DEVELOPMENT REVIEW BOARD  
TRANSPORTATION DEVELOPMENT

DRB Project Number: 1000111  
Altura Complex

SUBJECT: Preliminary/ Final Plat

DRB Project Number: 1000111 Hearing Date: 4-18-2018

PLAT OF TRACT B1 AND B2 ALTURA COMPLEX WITHIN SECTION 11, TOWNSHIP 10 NORTH, RANGE 3 EAST, NEW MEXICO PRINCIPAL MERIDIAN CITY OF ALBUQUERQUE BERNALILLO COUNTY, NEW MEXICO JULY 2018

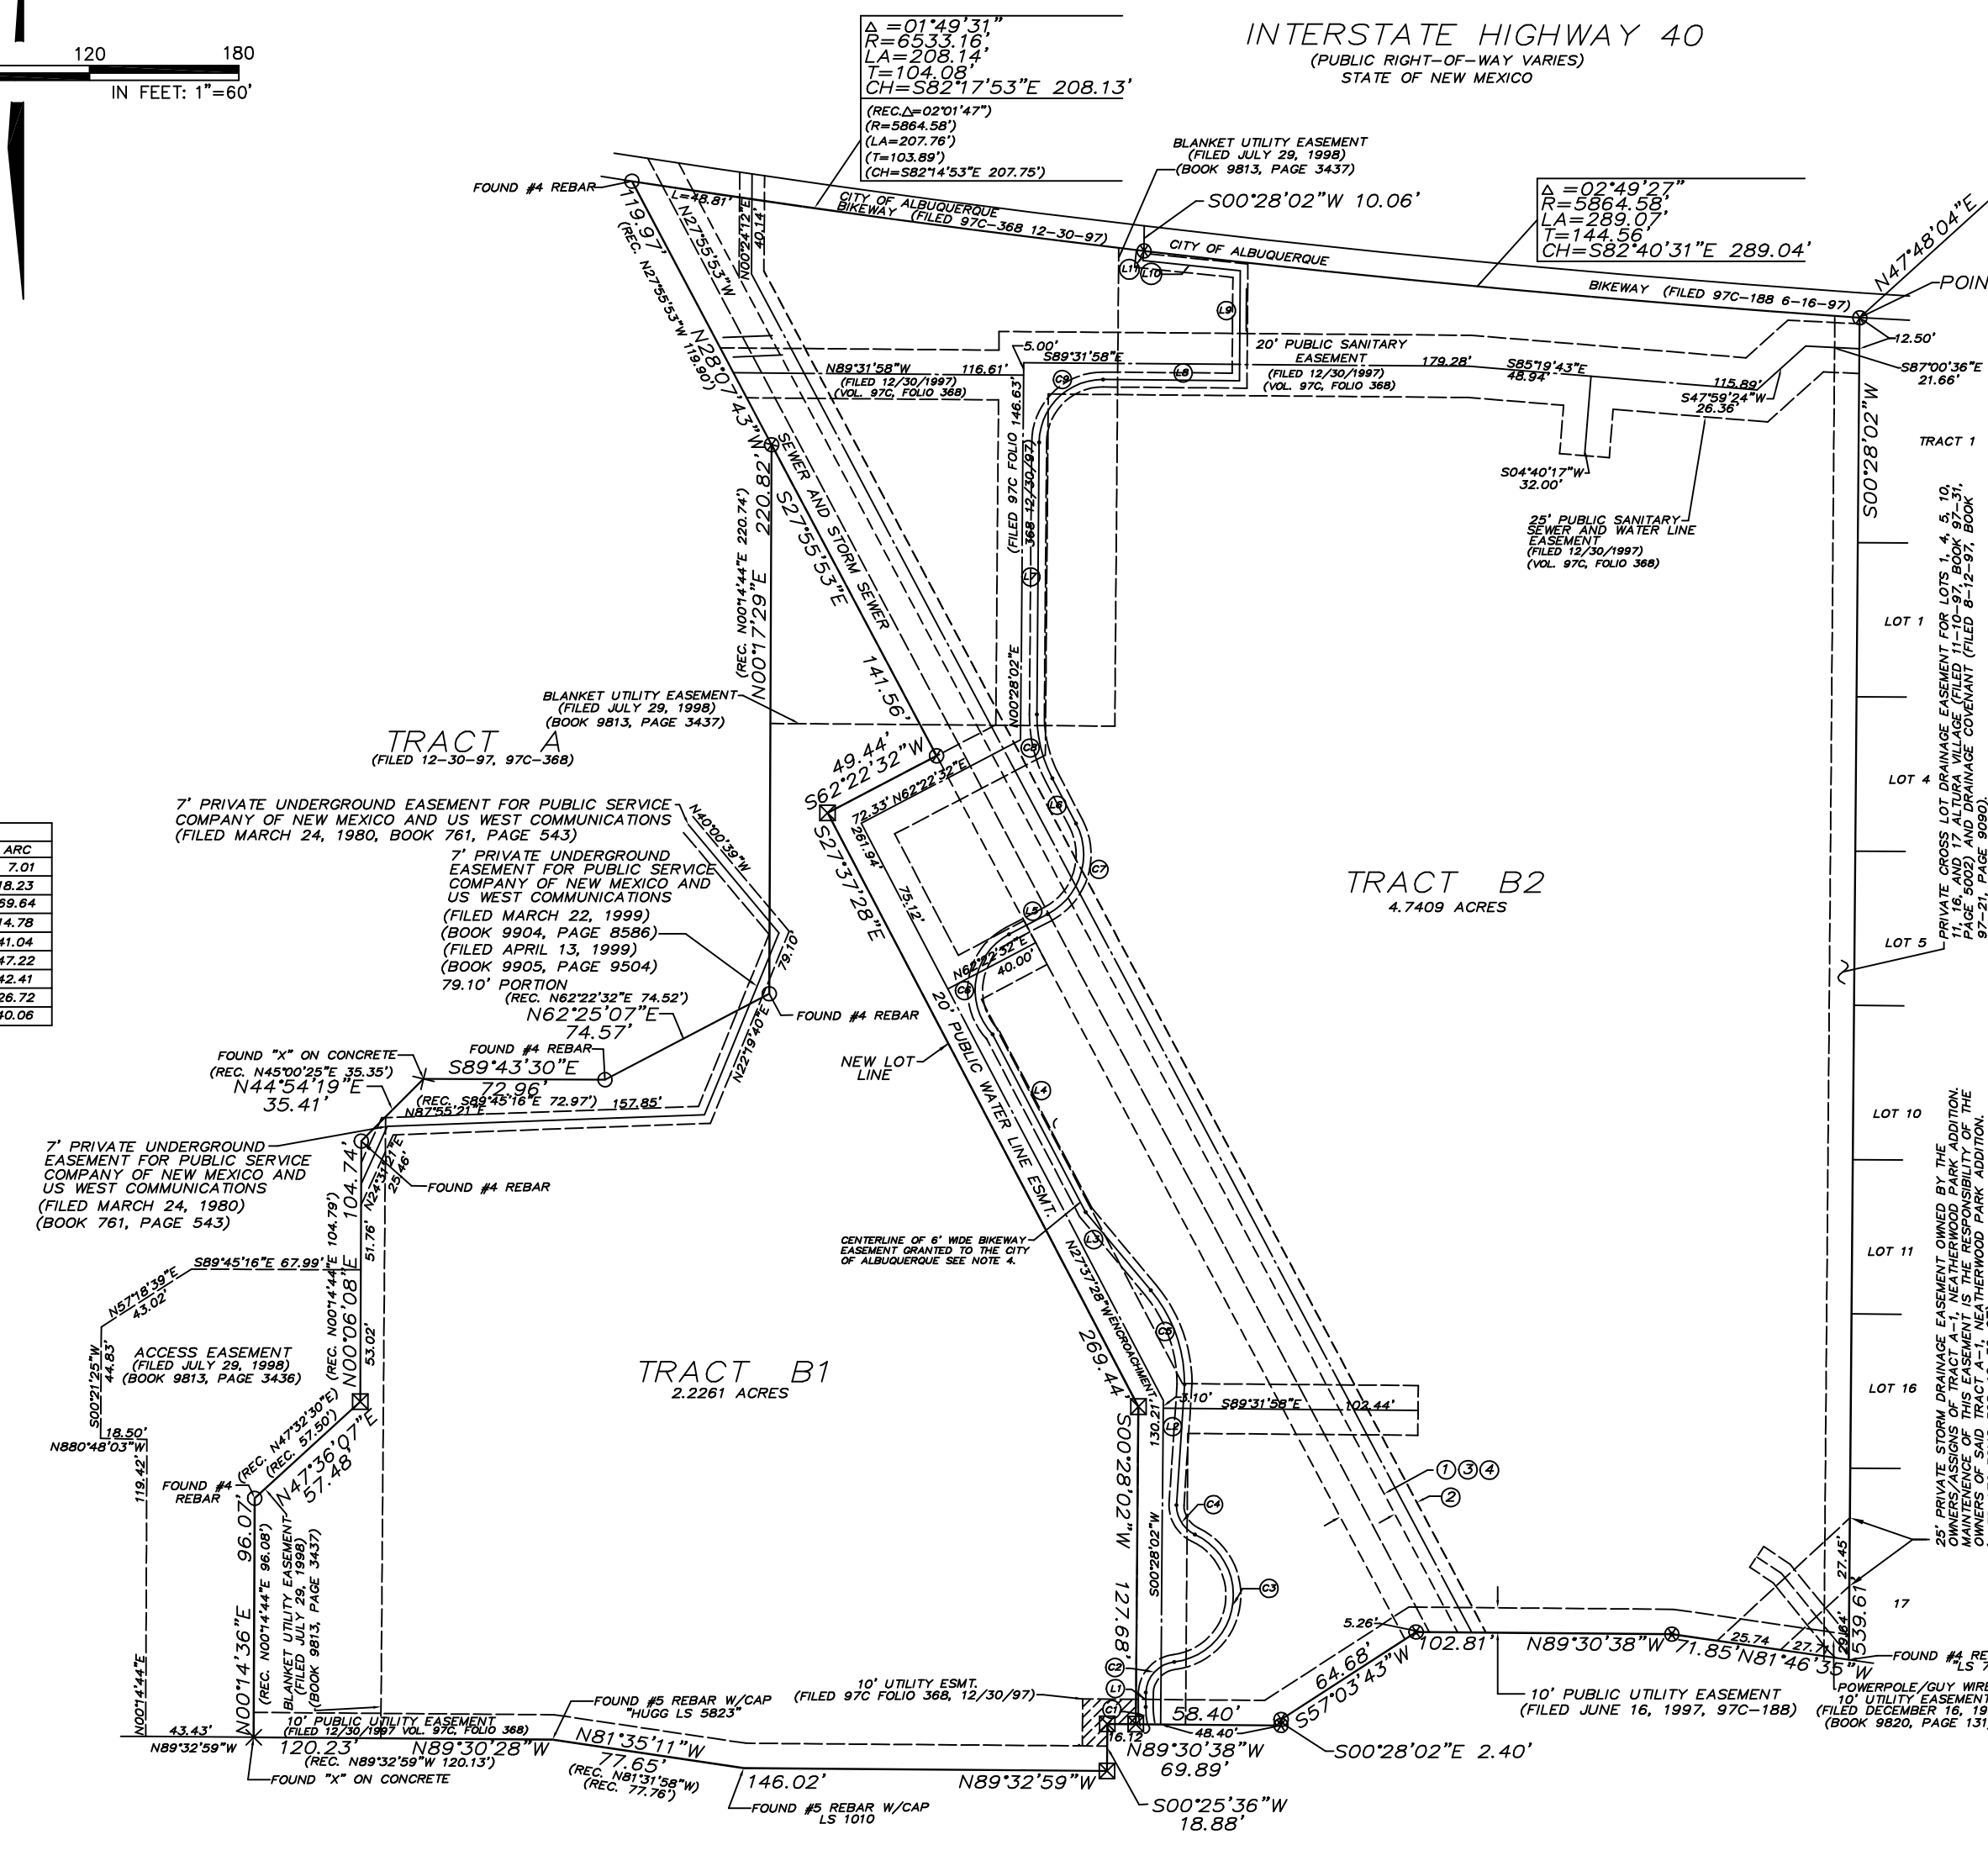
1. Provide a reciprocal shared access easement for lots B1 and B2
2. For final plat, any access easements need to be shown with all beneficiaries and maintenance responsibilities listed.

- A private cross lot drainage easement is required with Maintenance and Beneficiary.
